Application Ref:	3/2015/0462	 Ribble Valley Borough Council www.ribblevalley.gov.uk
Date Inspected:		
Officer:	AB	
DELEGATED ITEM FILE REPORT:		REFUSAL

Development Description:	Demolition of industrial storage buildings to the rear of 19-21 King Street and regeneration of the site to provide three two-storey dwellings comprising one detached and one pair of semi-detached.
Site Address/Location:	19-21 King Street Whalley BB7 9SP

PROPOSED PLANS &
ELEVATIONS.

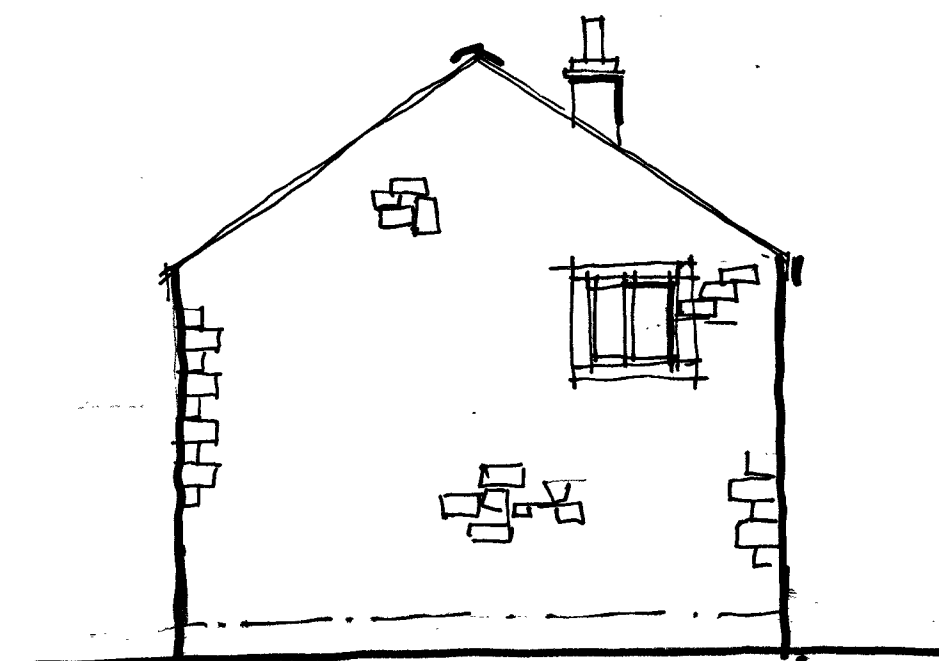
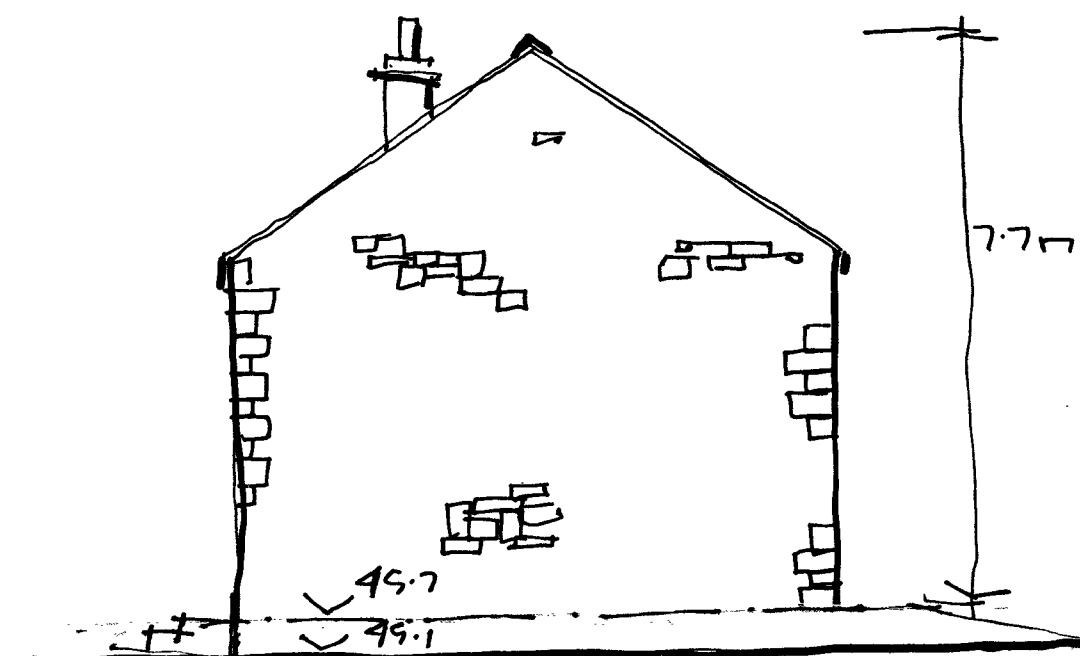
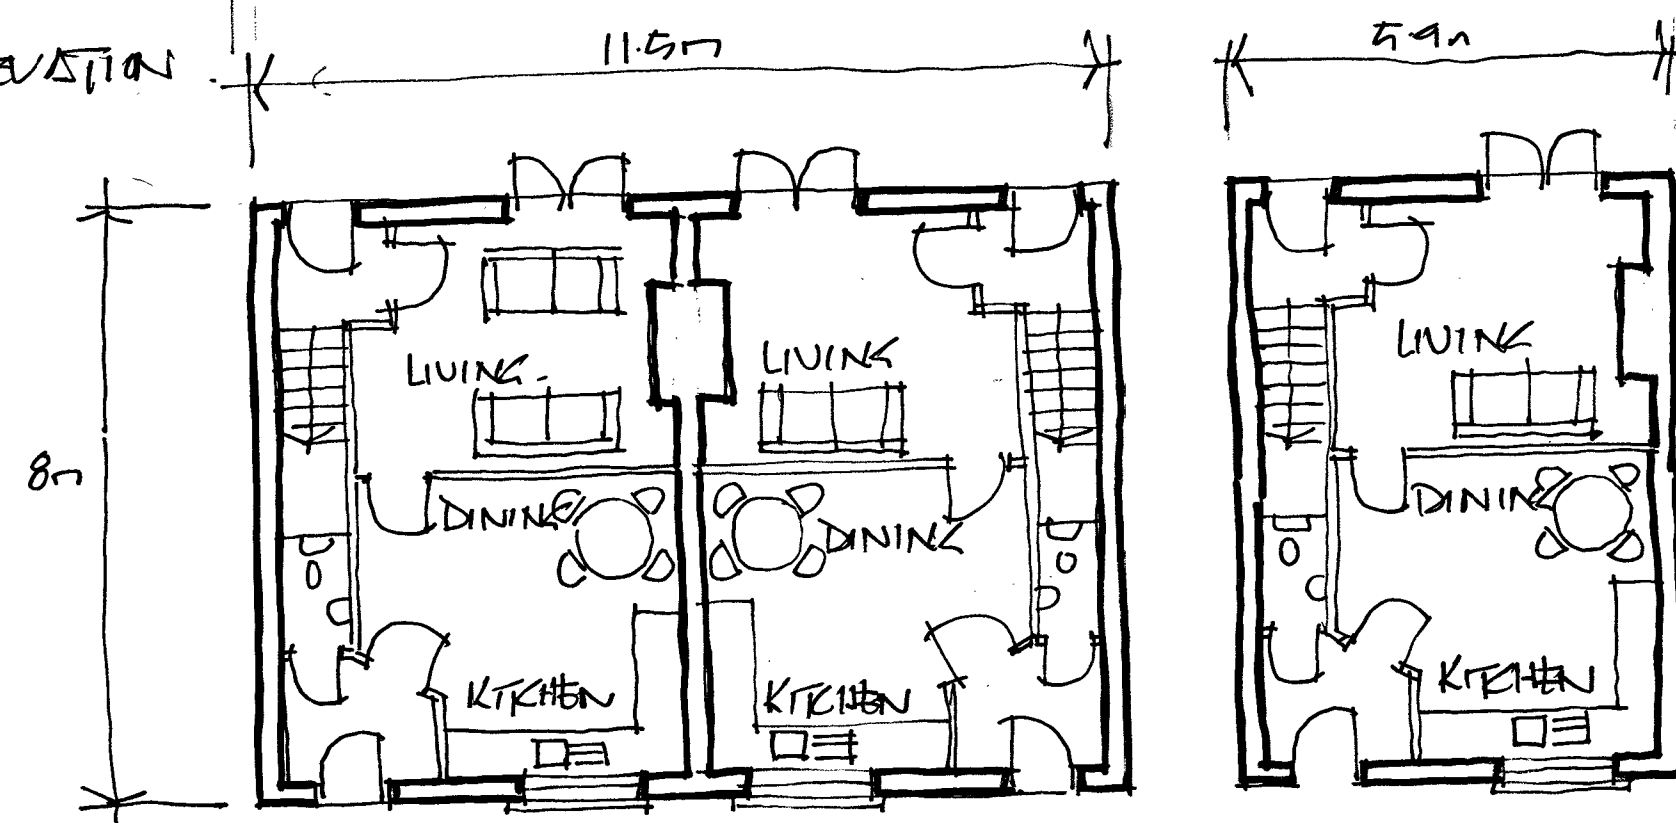
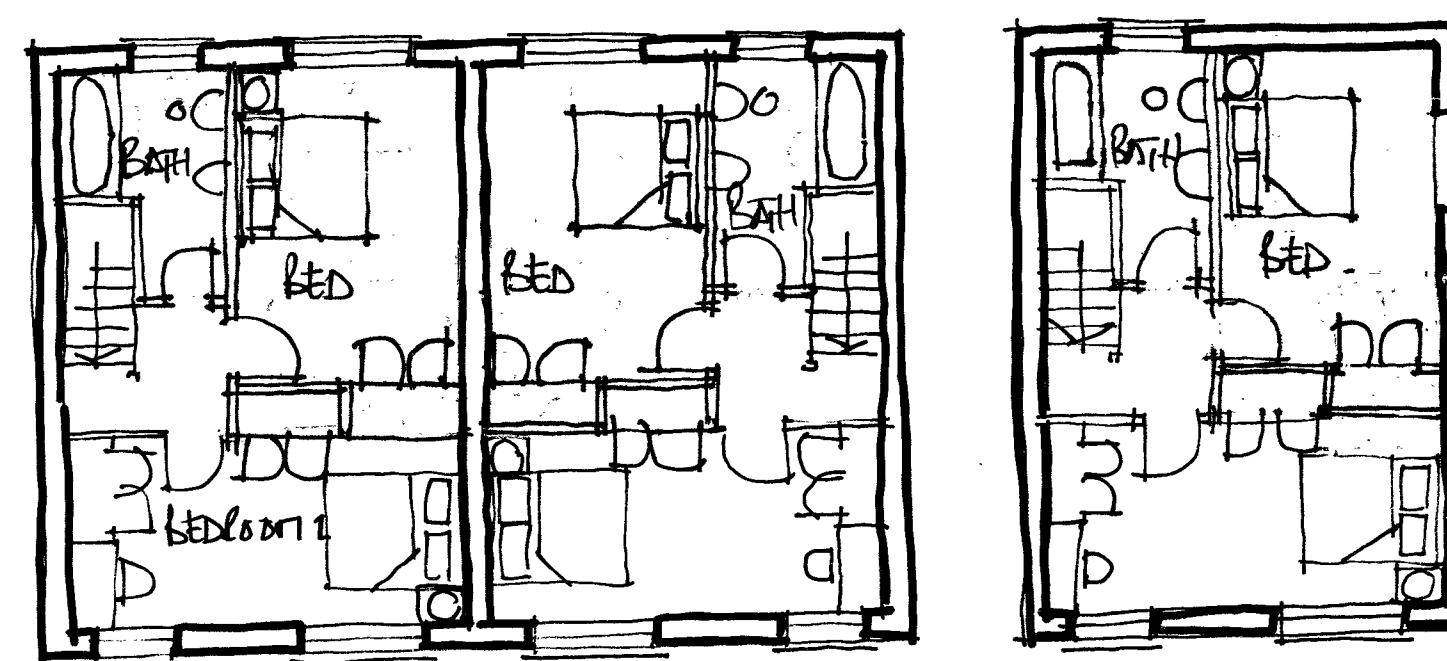
Outlook from the rear windows of nos.15-23 King Street would be improved by the replacement of the existing buildings with three relatively small dwellings. However, there are serious concerns regarding the effect that the proposals would have on the privacy of neighbouring householders and the future occupiers of the proposed dwellings. There would be 12m to 14m between the rear elevations of the proposed dwellings and the rear elevations of nos.17, 19 and 23 King Street. The first floor windows of unit no.1 would provide unrestricted views into the rear garden of no.23 King Street from a distance of 3m and would be around 11.6m from the rear elevation of this property. Whilst it is noted that this property is in the same ownership as the application site, there is a requirement to maintain an acceptable standard of residential amenity for both present and future occupants and the occupants of no.23 would experience unacceptable harm to their residential amenity through loss of privacy.

It is noted that the applicant has amended the layout of unit no.3 so as to remove the first floor habitable room window on the rear elevation and therefore overcome any overlooking and loss of privacy that would arise from its relationship with no.17 King Street. However, the bedroom window has been relocated to the side elevation of unit no.3 and would now directly overlook the rear garden of no.15 King Street resulting in significant harm to the residential amenity of these neighbouring occupants through overlooking and loss of privacy.

With regards the level of residential amenity provided by the proposed dwellings, the rear elevations of dwelling nos. 1 and 2 would be located at a distance of around 3.5m from the gable of an existing blank two storey outrigger that extends from the rear of no.21 King Street. As a guide, there should be at least 12m between the windows of habitable rooms and any two storey blank gable. This arrangement would give rise to an unacceptable and oppressive outlook from the rear living room and bedroom windows of dwelling nos. 1 and 2 and would lead to the overshadowing of a substantial proportion of the rear garden area and rear windows for a large part of the day resulting in an undesirable level of daylight and sunlight. This arrangement would be simply unacceptable.

| 01 | The proposal would result in the creation of a poor standard of residential accommodation that would be of detriment to the living standards and amenities of future occupiers by virtue of its limited privacy, outlook and natural light, contrary to Policy DMG1 of the Ribble Valley Core Strategy. |
| 02 | The proposal, by virtue of its layout and design, would lead to overlooking of neighbouring rear windows and garden areas leading to a loss of privacy that would have a severely detrimental effect upon the residential amenities of adjoining neighbours. This is considered contrary to Policies DMG1 of the Ribble Valley Core Strategy. |

Proposed Site Layout

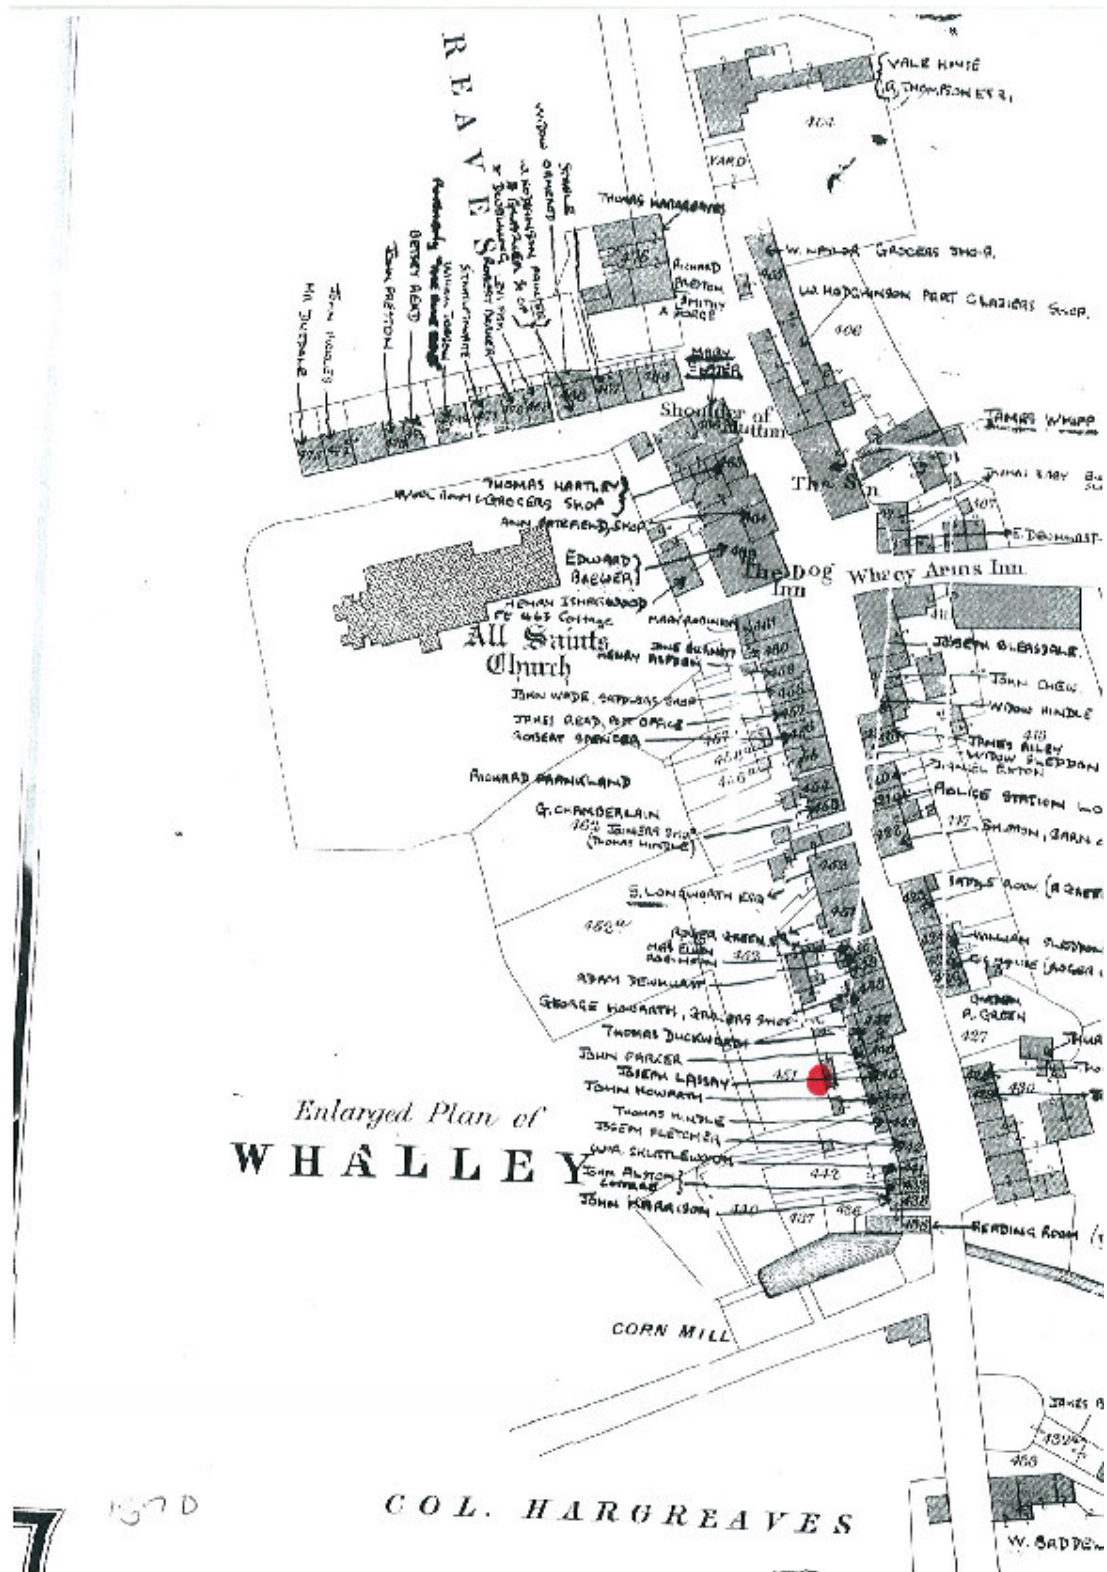
No objection to the proposal in principle. The vehicular access off King Street is narrow and unadopted and has no turning facilities and any deliveries etc. to the proposed properties would have to reverse along the back street which should not be encouraged. Therefore suggests that the 2 visitor parking spaces be deleted and this area converted into a turning head with appropriate signage prohibiting parking.

The County Surveyor is largely satisfied with the proposed parking provision and has no objection to the proposal in principle. However, it is suggested that the 2 visitor parking spaces proposed on a separate parcel of land in the applicant's ownership be deleted and this area converted to a turning head to allow any deliveries etc. to the proposed properties to enter the back street in forward gear and avoid reversing down the narrow street.
